Re: Submission to AMENDED State Significant Development No. SSD 16-7684

Site: 241-249 Wheat Road, Cockle Bay

Proposal / Proposed Development: Stage 1 Concept ('Built Form Envelope')

Submission on behalf of: Tianlong Ribbon Pty Ltd (Future Owners of 'The Ribbon Hotel' at 31 Wheat Road)

SECTION G - NORTH TO SOUTH

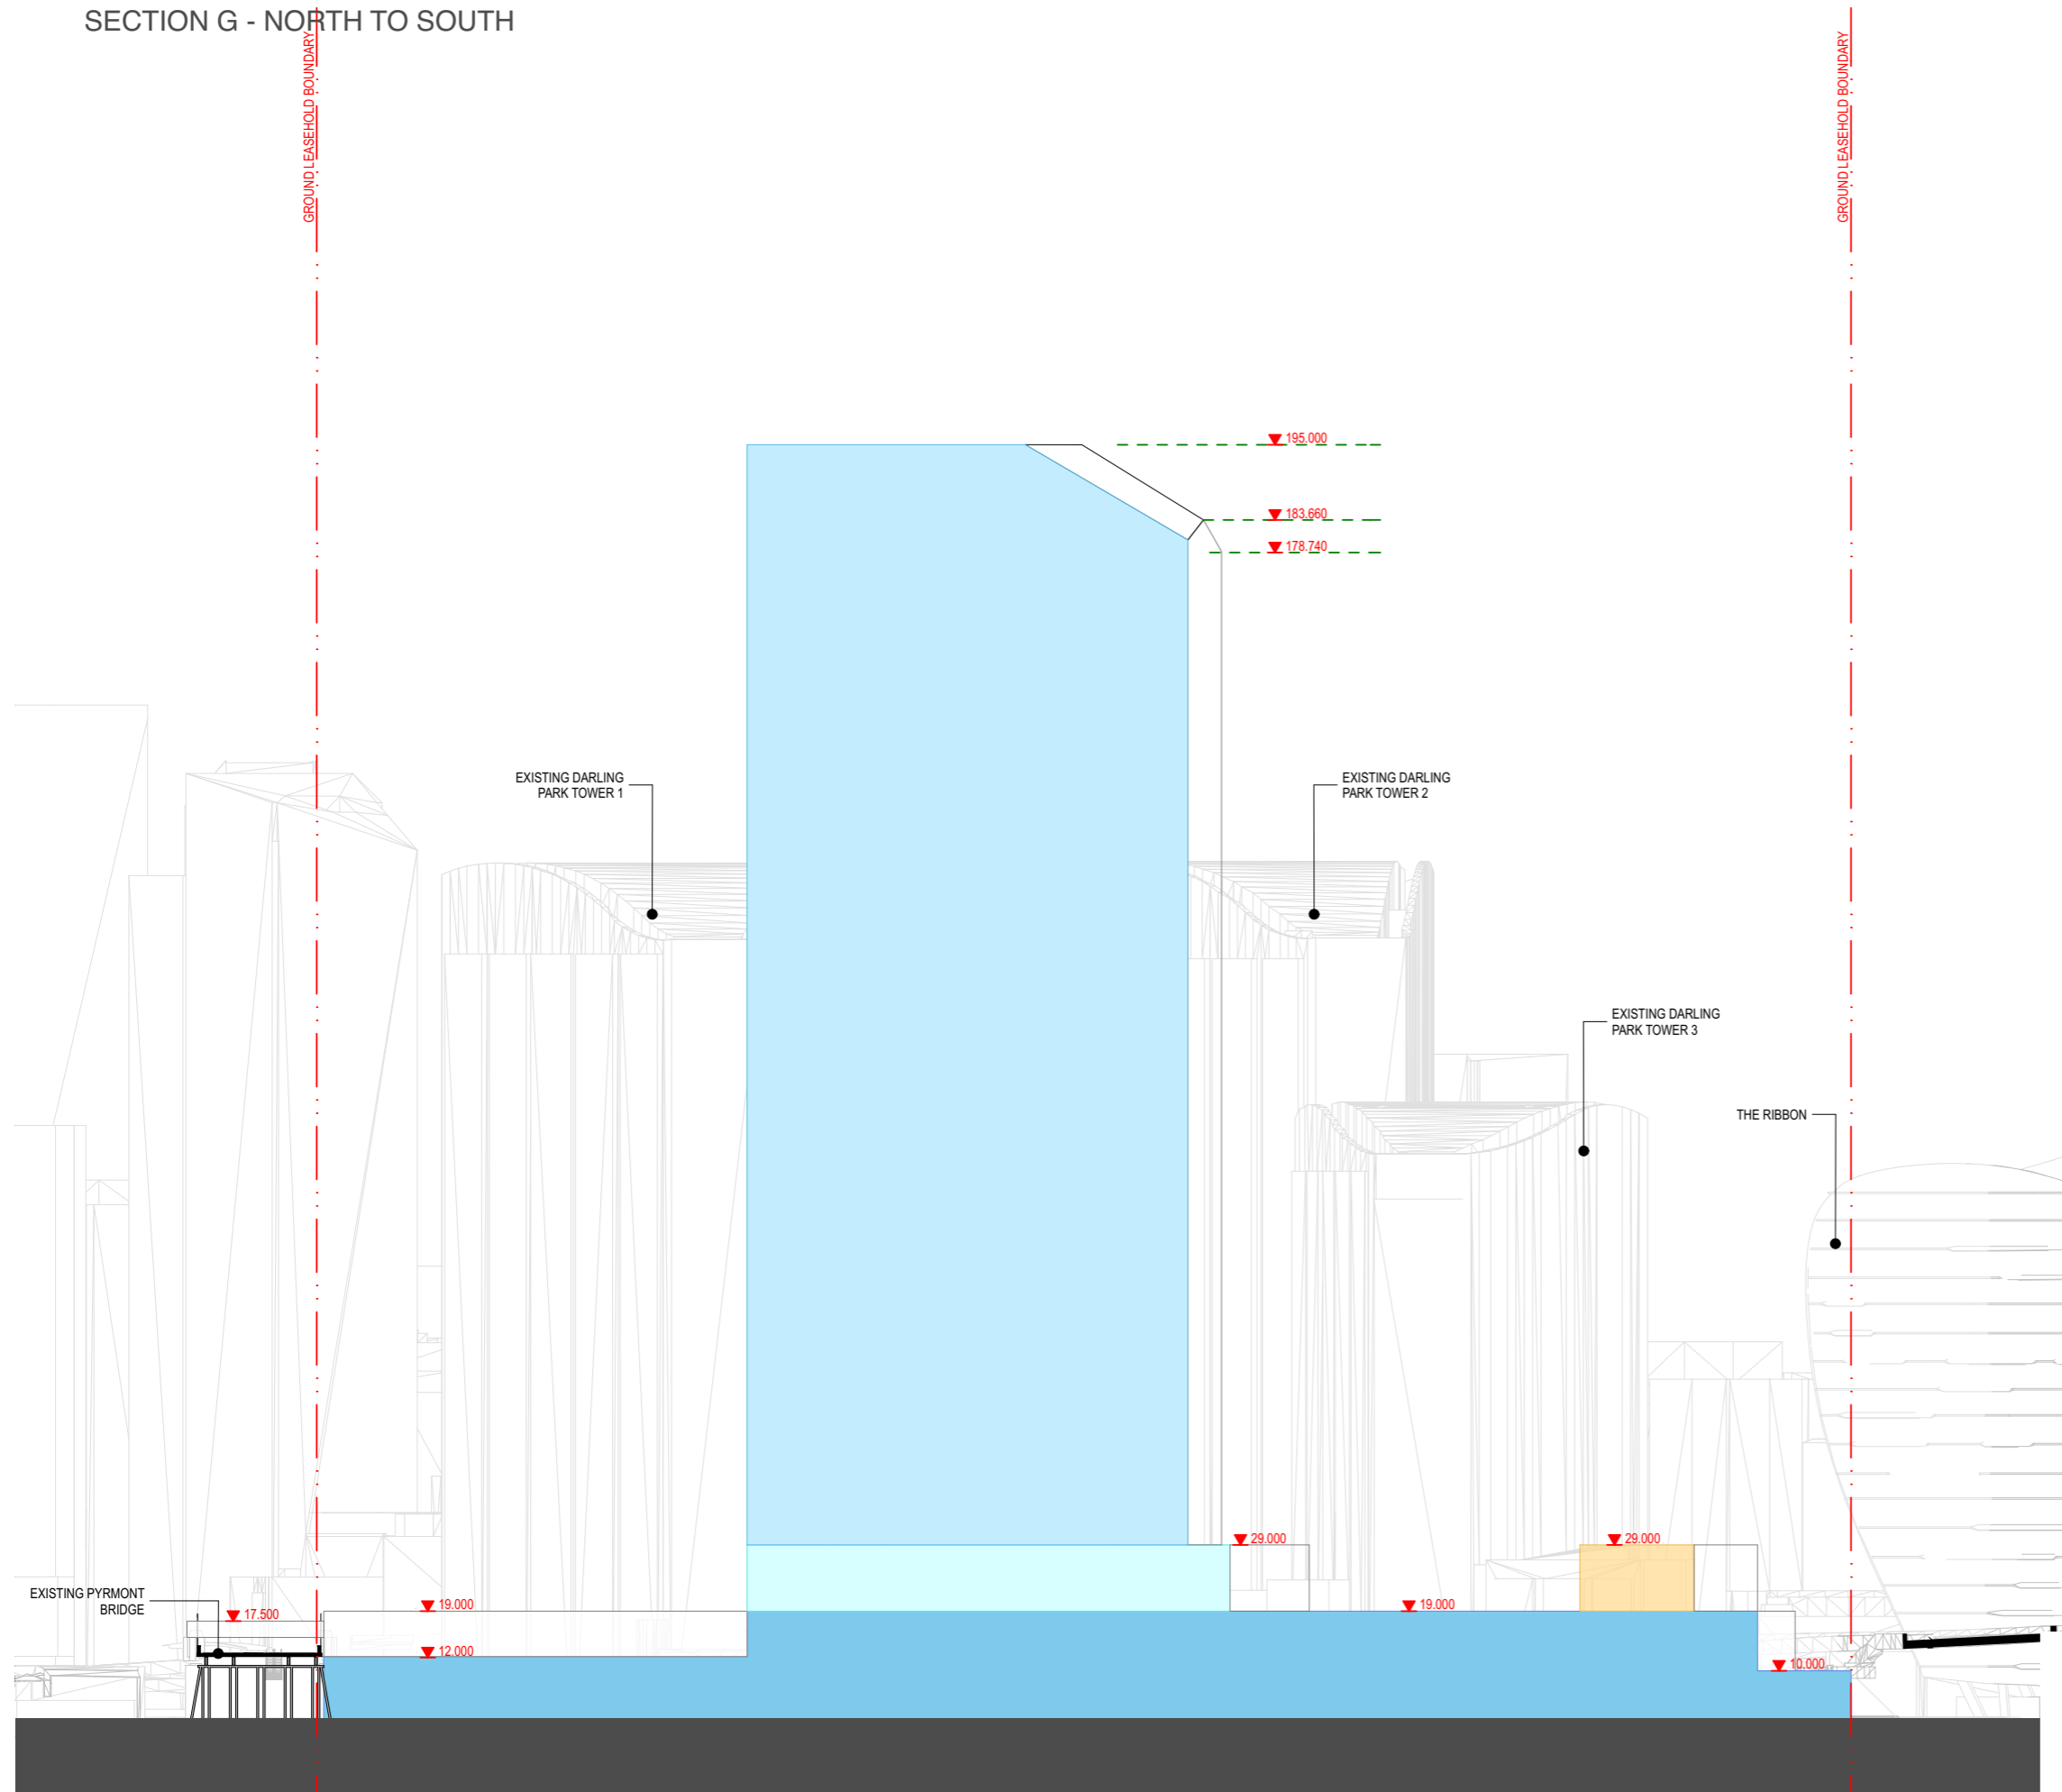
- 2.1. **Primary Tower Height:** The primary tower envelope has reduced in height from a maximum of RL235 to RL195 (see Figure 12 below), falling to RL179 in south-west corner. However, at RL195 this building still dominates the waterfront and surrounding buildings (see visual study below) and is potentially inconsistent with the city skyline and lowering of heights towards Cockle Bay. Whilst our client agrees that a 'point tower' is likely to have less impact than a squat continuous 'podium wall' building (of similar GFA) and the site can certainly support some height and FSR, the amended scheme does not produce appropriate urban design and amenity outcomes consistent with the planning for the Darling Harbour area.

- a) The primary tower envelope has moved south by ~30m i.e. closer to The Ribbon Hotel (see Figure 10 above). This is called the 'Central Tower' option (in comparison to the original 'Northern Tower' option in the original scheme). In the original proposal the southern edge of the primary tower was ~130m from the southern edge of the leasehold boundary. In the Amended proposal it is closer to 100m.
- b) The reduction in height appears to be solely in response to the shift in the tower location to the south but it still seeks to achieve the maximum height under the Tumbalong Park Sun Plane (see Figures 12 & 15 above). In effect, the reduction in height of the tower does not improve the bulk/scale/shadow relationship to The Ribbon Hotel and adjacent waterfront area as the reduced height is offset by greater proximity.

- 3.1. Push the Primary Tower at least another 10-15m north whilst providing good separation to Pymont Bridge and public open space;
- 3.2. Reduce the Primary Tower height to at least RL150 with no additional penetrations for roof articulation above that height;
- 3.3. Reduce the Ground Level Envelope at the southern end to accord with the indicative design shown for the Druiitt Street pedestrian bridge/waterfront access i.e. not permit it to extend to the southern boundary of the lease.
